**Application No:** 20/00631/DISC-2

**Proposal:** Discharge of Condition 6(ii) (parking provision for Building 103) of 16/01545/F

**Location:** Building 103 & 315 Heyford Park, Camp Road, Upper Heyford, Bicester, OX25 5HD

## **Transport Development Control**

Figure 3-3 - Car Parking Allocation

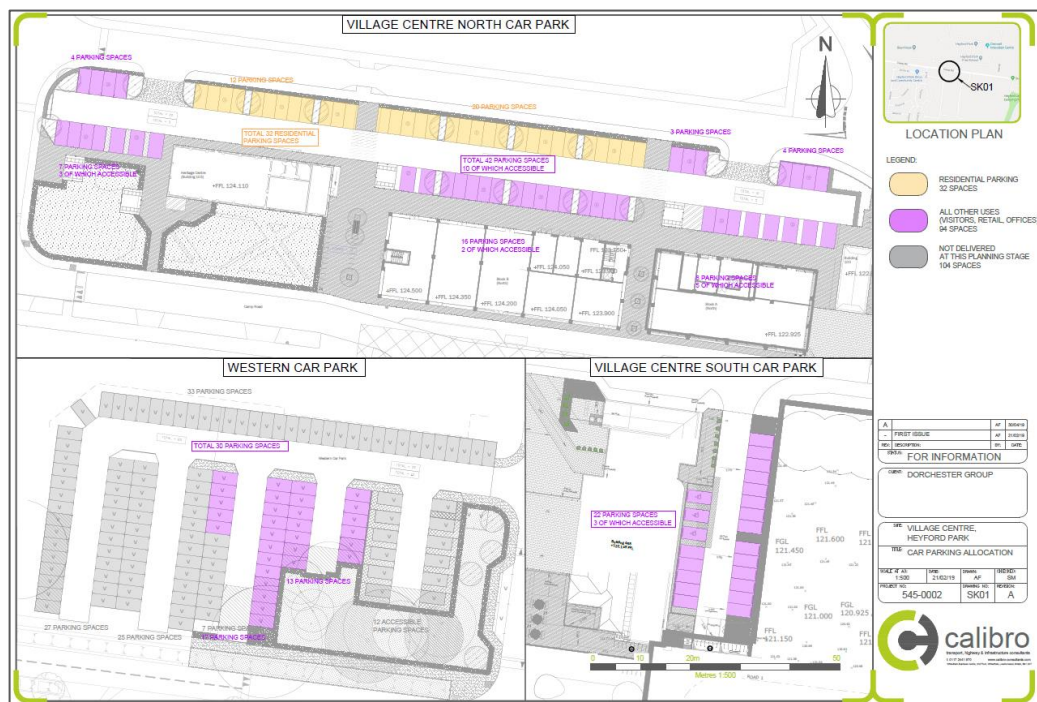
- Paragraph 3.5.3 states that visitor parking spaces “...*will not be specifically allocated...*”. This is not an acceptable approach. The County requires that visitor parking spaces are specifically allocated. **Reason for objection.**

- Section 3.7 presents a total parking provision of 126 car parking spaces. This determined by allocations according to standards for various uses together with a parking accumulation analysis. An additional 12 car parking spaces are proposed over and above the maximum weekday accumulation determined. This is not considered sufficient to provide for occasions when the accumulated demand for non-residential uses will be exceeded. **Reason for objection.**
